Your Ref: OWPC23082
Our Ref: FG/46/19/PL 10-04-2019
Please ask for:
Zac Denton

Town & Country Planning Act 1990 (as amended)
Town and Country Planning (Development Management Procedure) (England) Order 2015

Refurbishment of existing car park. Providing a permeable SuDS ground reinforcement grid paving system. Providing a level allocated car parking spaces.

East Of The Bluebird Cafe South Drive Ferring

01 PROPOSED SITE PLAN
Scale: 1:200

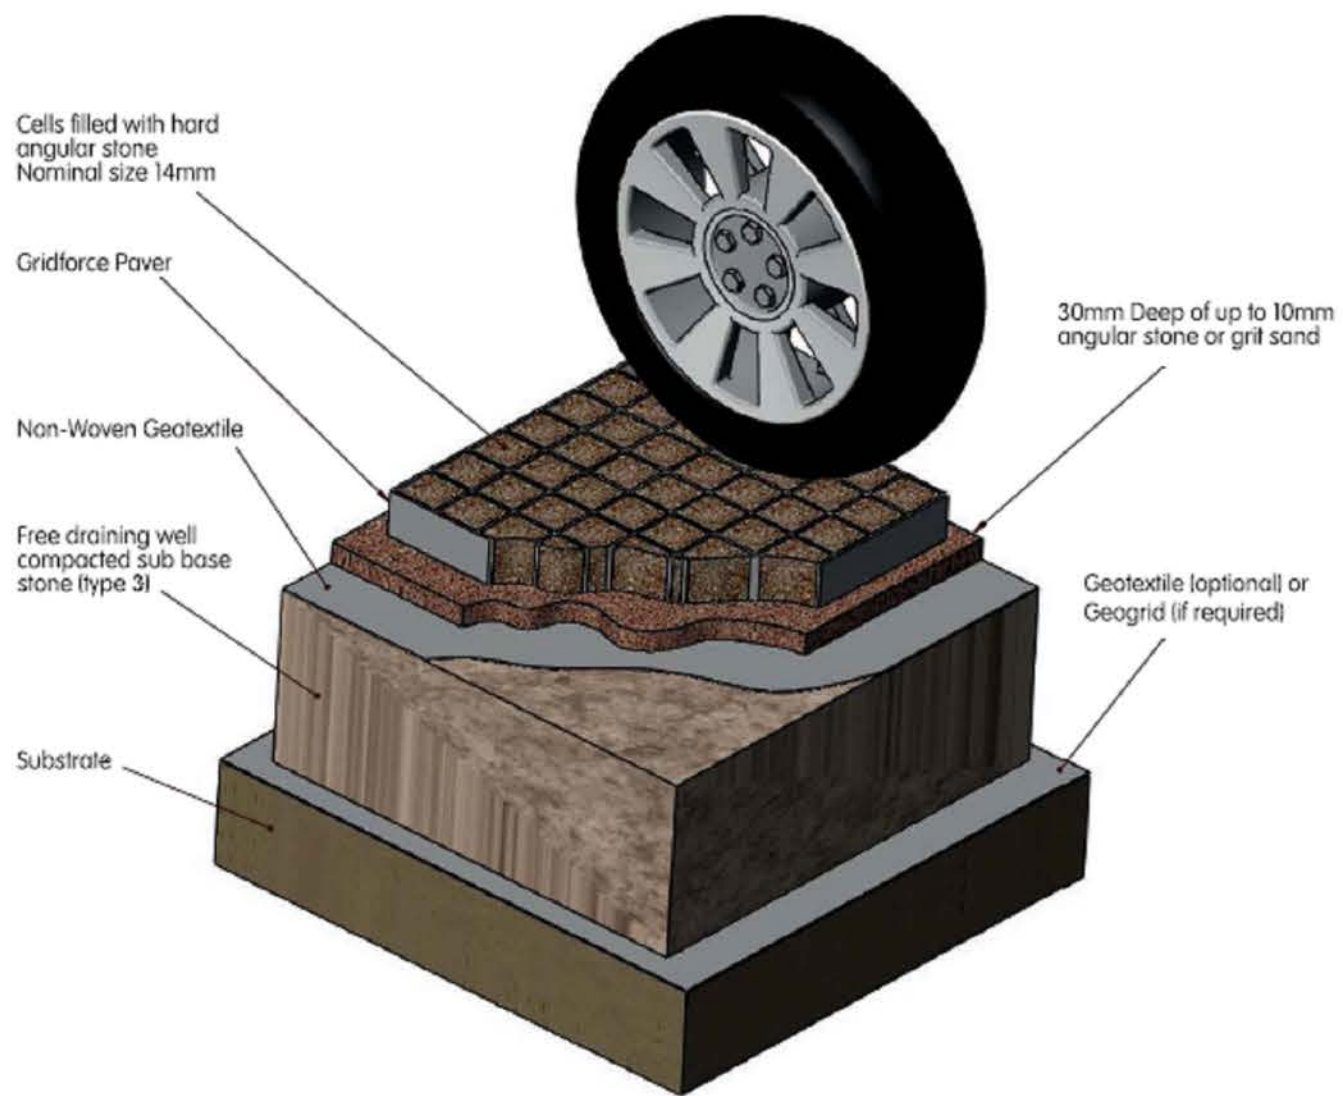
Ferring Conservation Group does not object to this application but would like to point out that there is a narrow registered footpath along part of the northern boundary of the site, not marked on the plans submitted but shown on the WSCC Definitive Map. This needs protection from parked cars and it is suggested that a condition might be attached to any consent, requiring a low wall to be built to prevent obstruction of the footpath.

Finally, it is not clear why the applicant has included revised plans of a roof line for the Caf itself, when there is no proposal in the application for a change to any of the buildings.
